25 November 2016

RE: Notice of Exhibition – Moorebank Precinct West Stage 2 (SSD 7709)

In response to the exhibition material, Campbelltown Council makes the following comments:

ALL TRANSVERSE LINEMARKING, PAVEMENT ARROWS AND CHEVRONS TO BE MARKED USING THERMOPLASTIC.

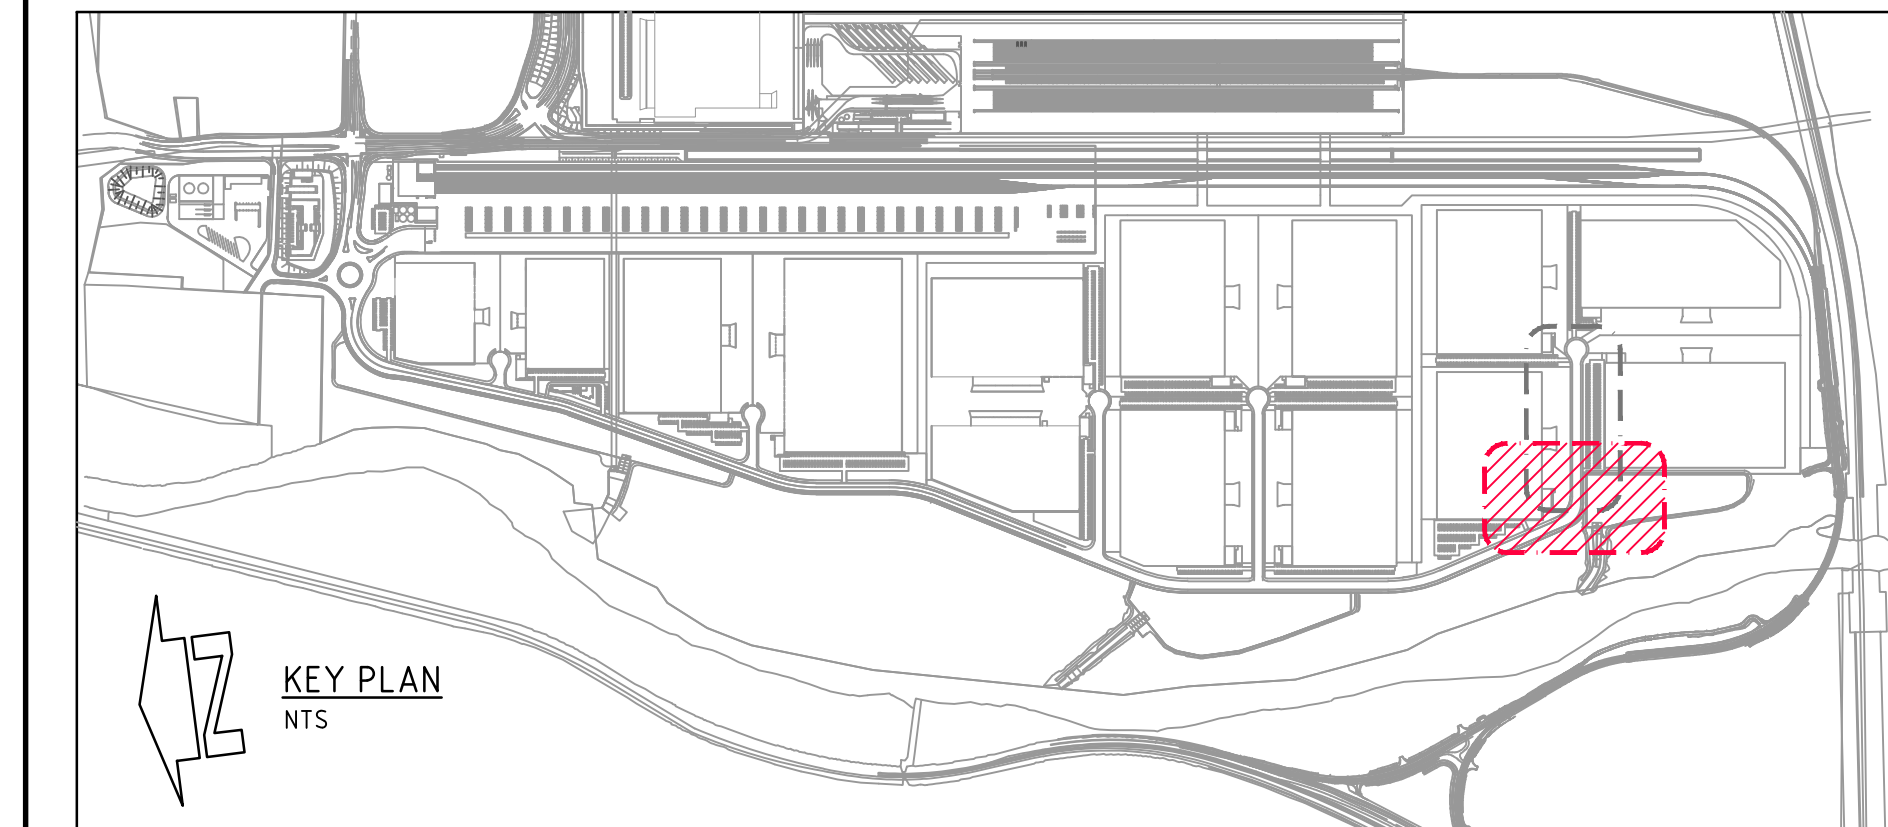
The proposed intersection design with Moorebank Avenue/Anzac Road appears to be inconsistent with the concept approval (SSD 5066) for the facility, refer to Schedule 4 – Condition E12:

All future Development Applications shall demonstrate how the main access to the site has been designed to prevent heavy vehicles associated with the facility from using Moorebank Avenue South, and should be accompanied by detailed engineering drawing(s).

Appendix 'G' to the current application clearly demonstrates that the intersection has been made viable for trucks (a-doubles maximum) to turn right onto Moorebank Avenue and head south, which is not considered to be compatible with the concept approval.

Even if the proponent suggests that the trucks would be heading in that direction to access Precinct East only and not continuing on to utilise the Cambridge Avenue Georges River crossing, the fact remains that the proposal is not consistent with the condition and there are no safe-guards proposed, aside from 'education of drivers' accessing the terminal. It could be argued that if the PAC considered driver education to be sufficient, that the wording of Condition E12 would have been different.

- 3.7 The proposal has assessed the intersections along Cambridge Avenue to determine impacts of the development. As with the Glenfield Waste proposal, the issue is not the intersections, but the number of heavy vehicles trying to pass on the causeway itself. Any increase could have a negative impact on safety. This has not been addressed by the current application and is of particular importance to Council, noting the intersection design in Appendix 'G'.
